KITITAS COUNTY

MEMORANDUM

TO: All Staff
FROM: Justin Turnbull, County Surveyor 
DATE: December 18, 2020
SUBJECT: County Survey Review of BL-20-000224 Flowers

UNIFIED SITE PLAN
FOR
TAX PARCEL NUMBERS 832534 AND 221136
FOR
BEN & LINDSEY FLOWERS

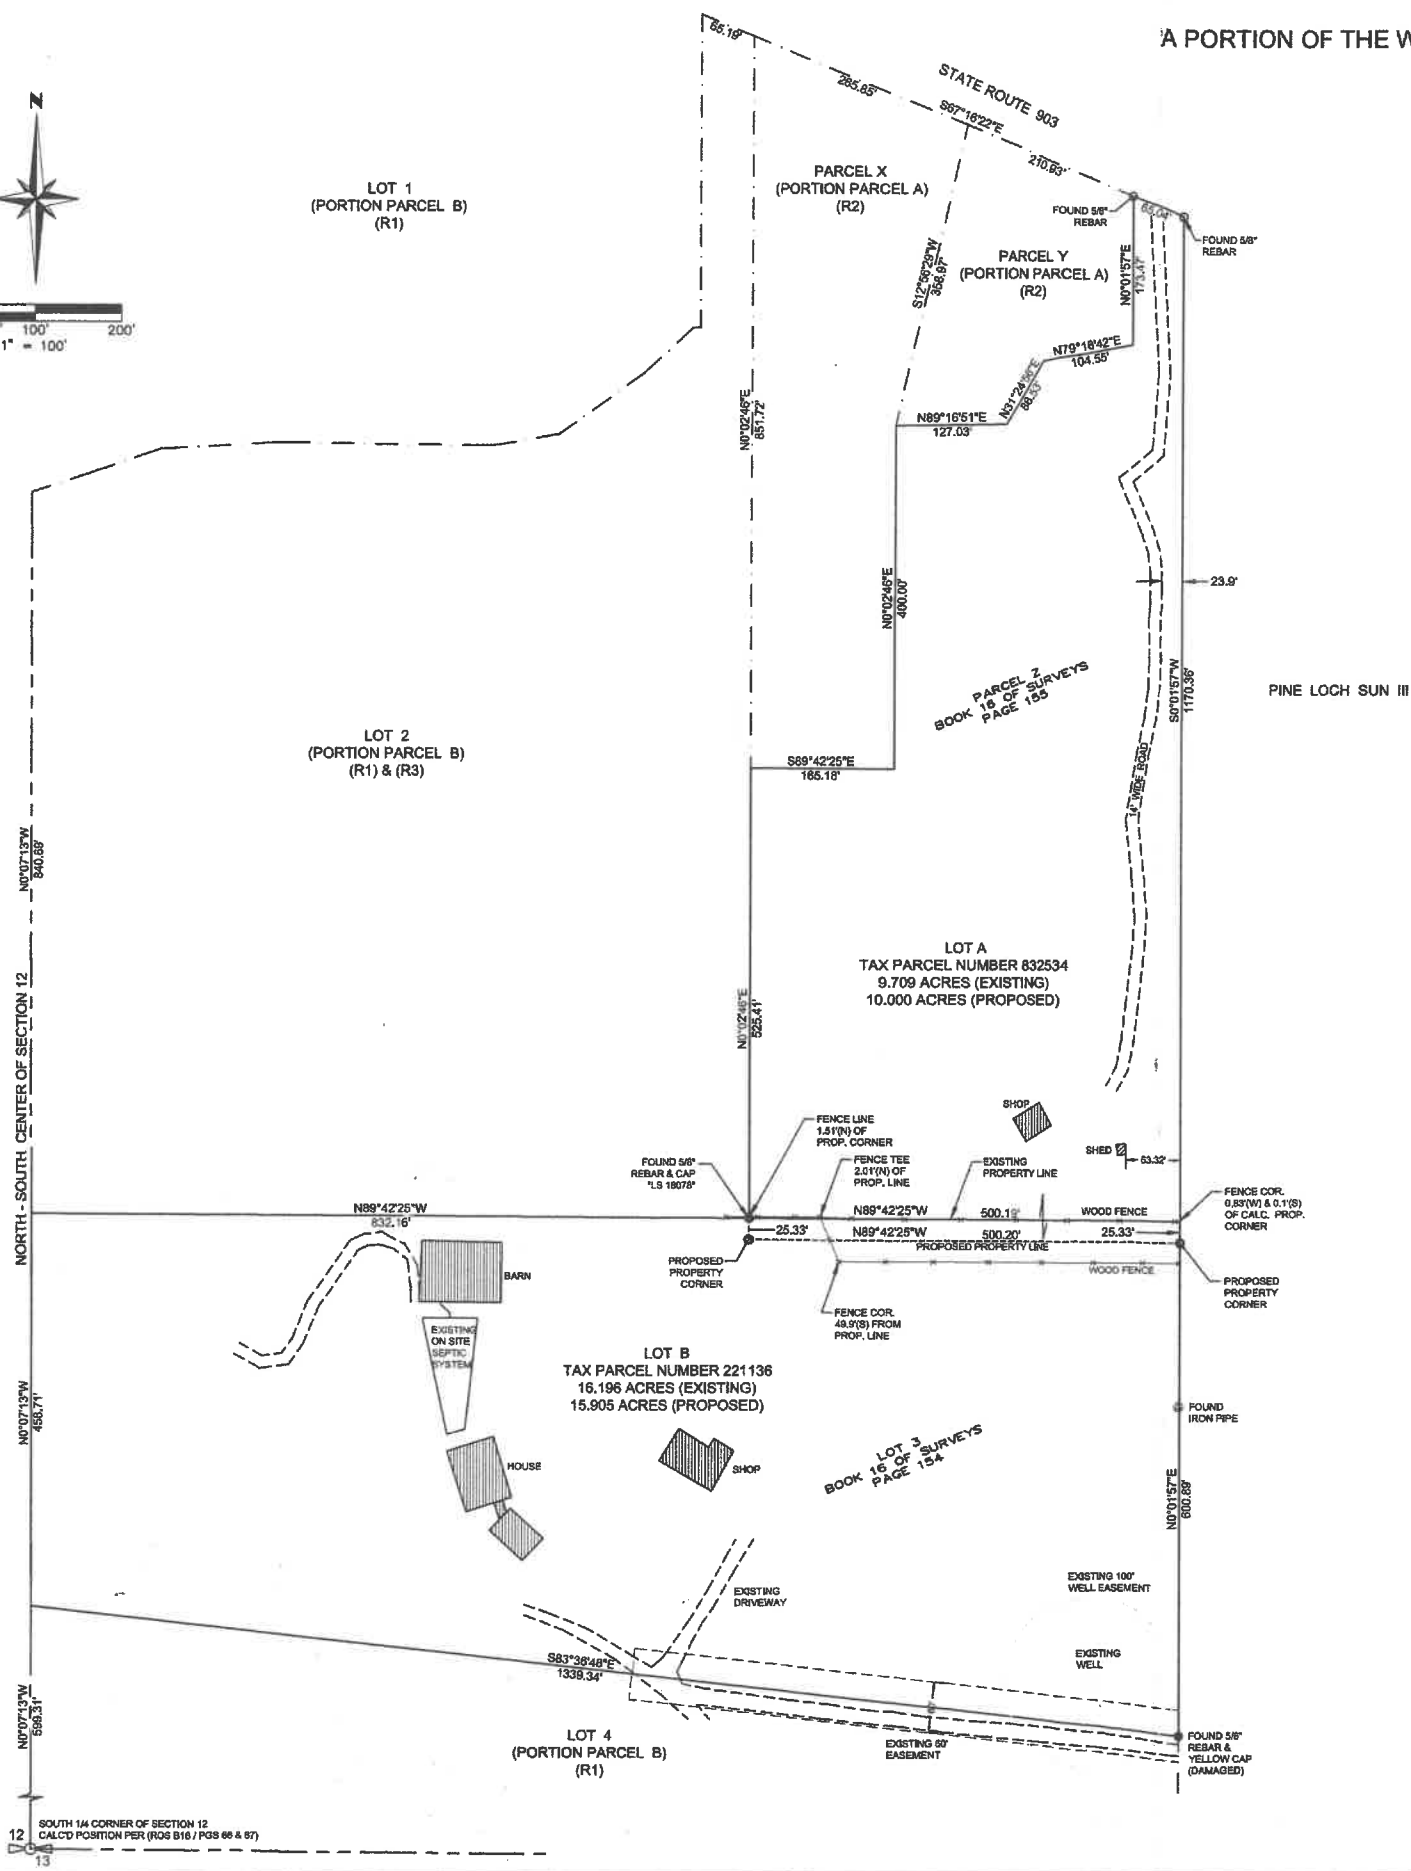
1. Sheet 1 is missing the legend.
